From: Carol Reynolds
Sent: 17 November 2017 14:51
To: Planning.Responses
Cc: Anita Gardner
Subject: FW: Planning Consultation on: LU/307/17/PL

APPLICATION LU/307/17/PL

Description of Works: Demolition of promenade shelter & construction of cafe & kite surfing school with roof terrace & associated works

Ground floor plan | proposed

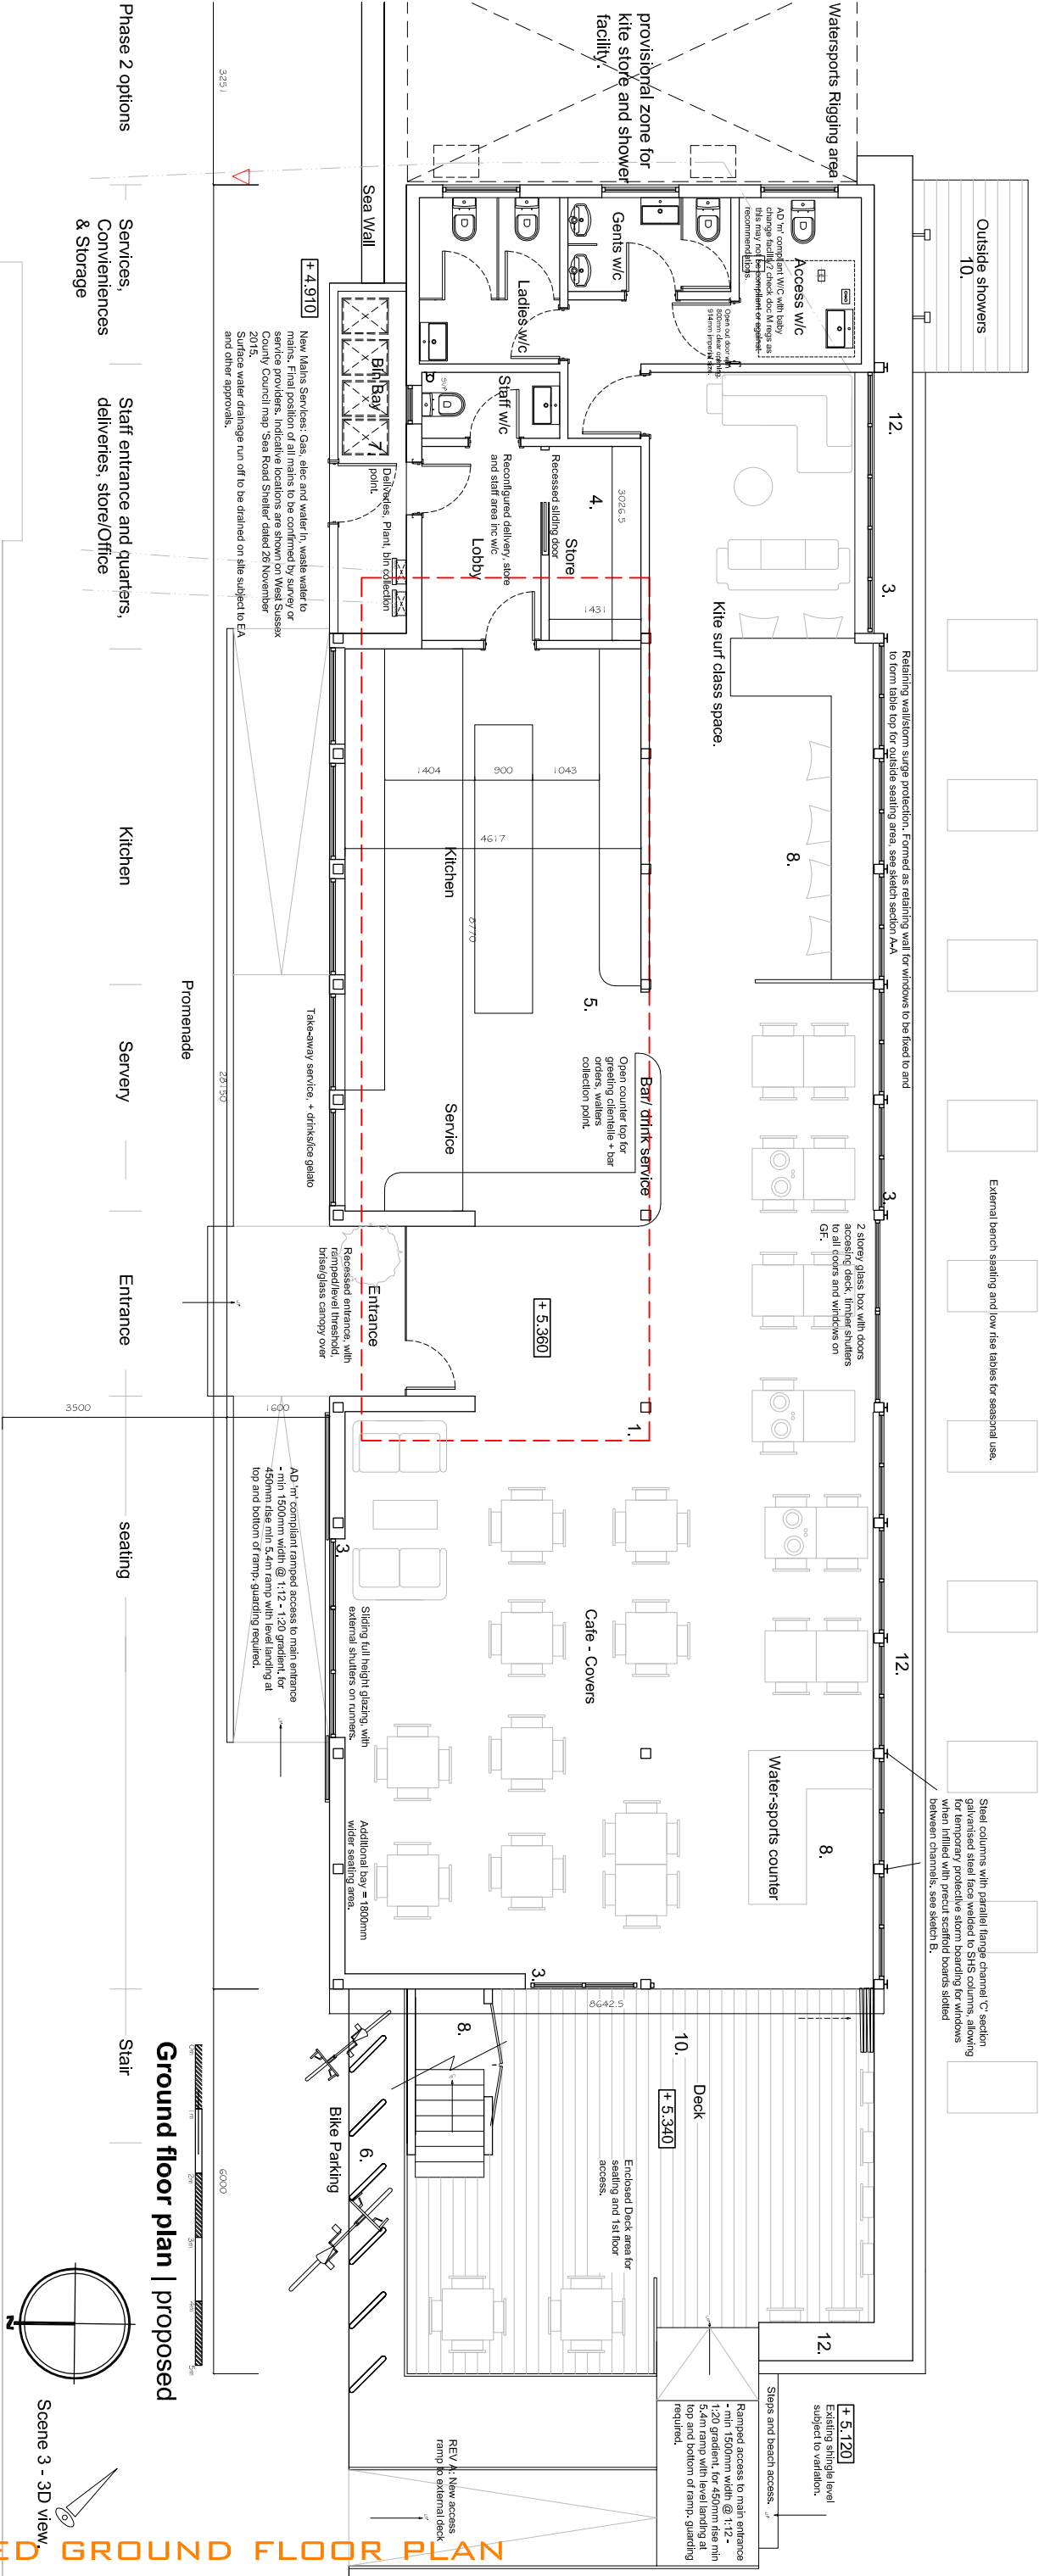
Public The current proposal provides sufficient provision for up to and including 200 persons. (see Arun District Council 'Provision of Sanitary Accommodation in Food Businesses – Cafes/Restaurants'). The necessary provision for the stated number of customers ie 50 indoors and up to 200 outdoors, (which should include those attending the kite etc school), is:-

Male: 2 WC's, 2 Urinals and 3 wash hand basins

Female: 4 WC's and 3 wash hand basins

There is therefore insufficient provision.

Staff: The one staff toilet shown will be suitable and sufficient for up to 5 male and female staff members. Greater provision may be necessary as described by the 1992 Workplace (Health, Safety and Welfare) Regulations.

hot and cold water and proper drainage, should be provided at the kitchen entrance proximal to the bar. There must be at least 2 sinks one for washing vegetables and meat another for dishwashing. There should be a sink at any bar.

Consideration should be given to reconfigure the staff WC and lobby thereto, to increase the food /food equipment storage provision. I would advise that should the staff WC entrance be repositioned to within the public provision (but maintained as 'private') then the whole lobby and store area could be utilised for this purpose. Please contact this department for further advice.

Should you wish to retain the existing layout of staff WC/ lobby/store then each door to the lobby must be fitted with self-closing doors to all entrances excluding the external door. The sliding door to the store will not be suitable if food is intended to be stored here.
